CITY OF ALBUQUERQUE

Re: DCI Southwest Mesa
8217 Central Ave NW
Traffic Circulation Layout
Engineer's Stamp 08-03-16 (K10D056)

Based upon the information provided in your submittal received 08-10-16, the above referenced plan cannot be approved for Building Permit until the following comments are addressed:

date
August 3, 2016
project no.
35-122
sheet no.
C4.01
TRAFFIC CIRCULATION LAYOUT

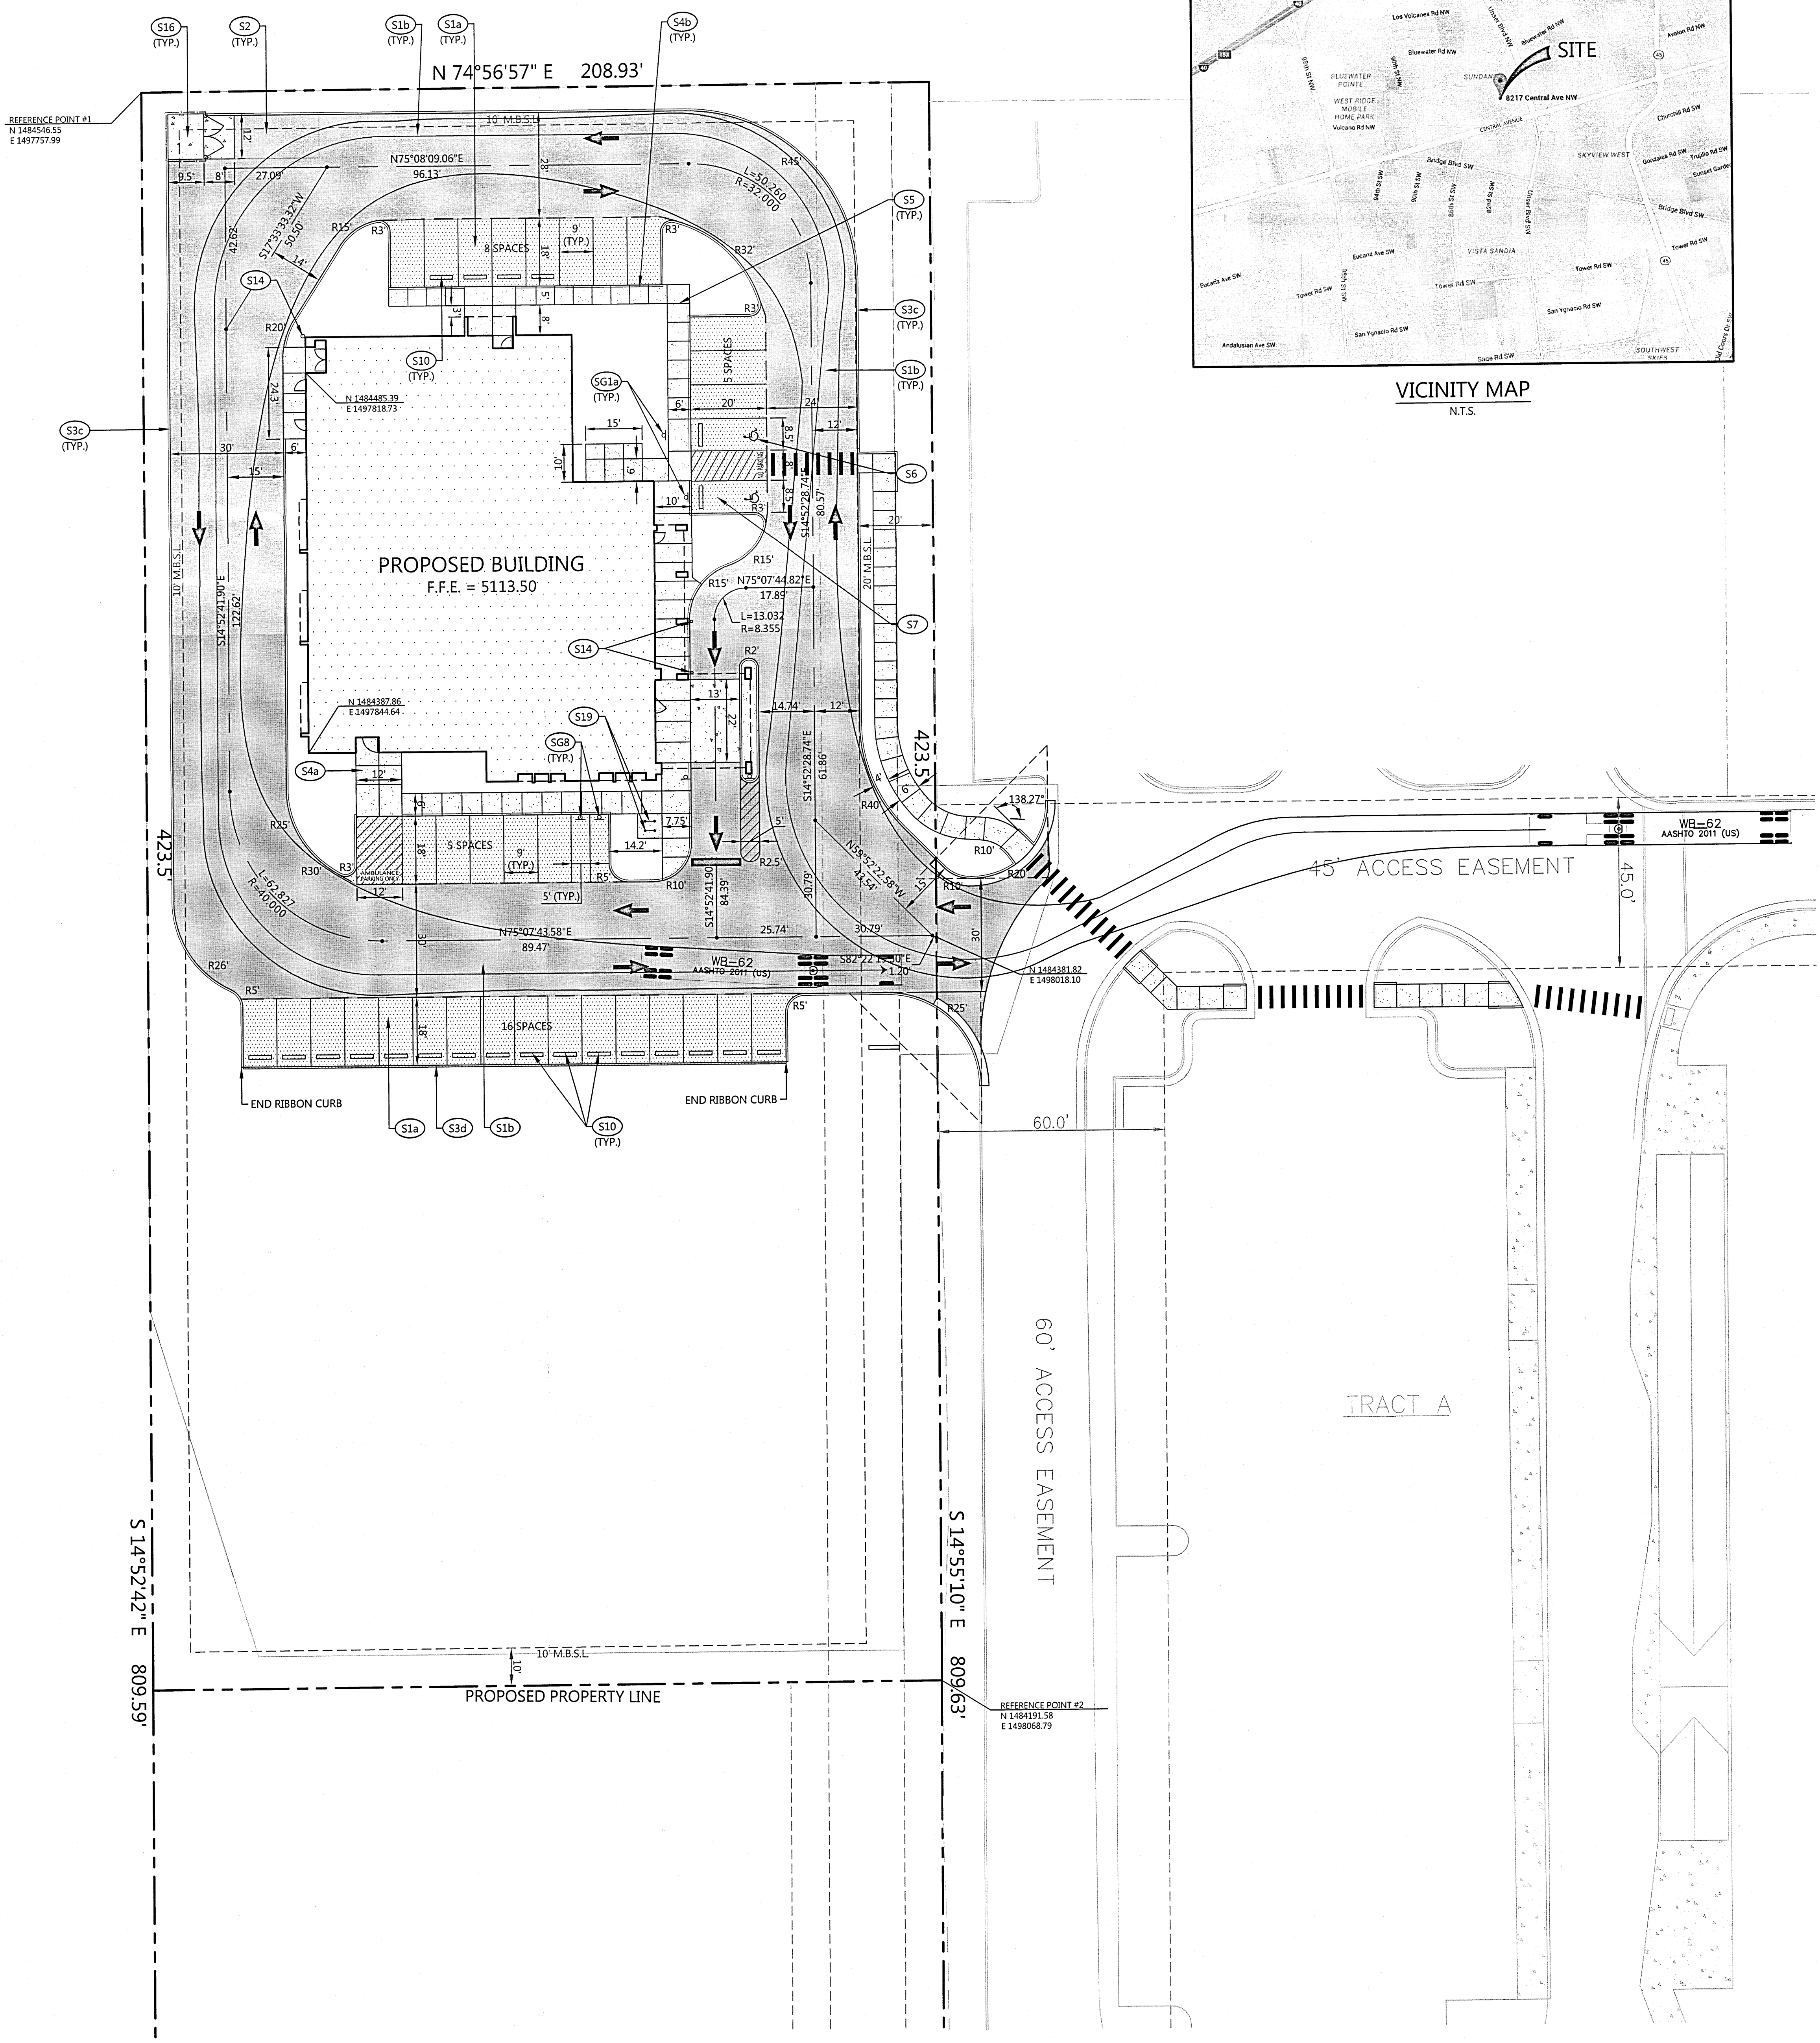
1. Identify and provide a copy of all existing access easements and rights of way width dimensions. It is difficult to locate the project. Provide information such as main cross streets and existing developments.

2. Clarify existing property lines and proposed property lines.
3. The ADA accessible parking sign must have the required language per 66-7-352.4C NMSA 1978 **"Violators Are Subject to a Fine and/or Towing."** Please call out detail and location of HC signs.

4. The ADA access aisles shall have the words **"NO PARKING"** in capital letters, each of which shall be at least one foot high and at least two inches wide, placed at the rear of the parking space so as to be close to where an adjacent vehicle's rear tire would be placed. (66-1-4.1.B NMSA 1978)

5. Per the Zoning code a 6 ft. wide ADA accessible pedestrian pathway is required from the public sidewalk to the building entrances. Please clearly show this pathway and provide details.

6. Provide a detail of the curbing surrounding the property. A minimum 6" or max 8" high concrete barrier curb or other acceptable barrier between landscaping and parking areas and/or drive aisles.

7. One-way vehicular paths require pavement directional signage and a posted **"Do Not Enter"** sign at the point of egress. Please show detail and location of posted signs.

8. Please add the following note to the clear sight triangle: "Landscaping and signage will not interfere with clear sight requirements. Therefore, signs, walls, trees, and shrubbery between 3 and 8 feet tall (as measured from the gutter pan) will not be acceptable in this area."

9. Please specify the City Standard Drawing Number when applicable.
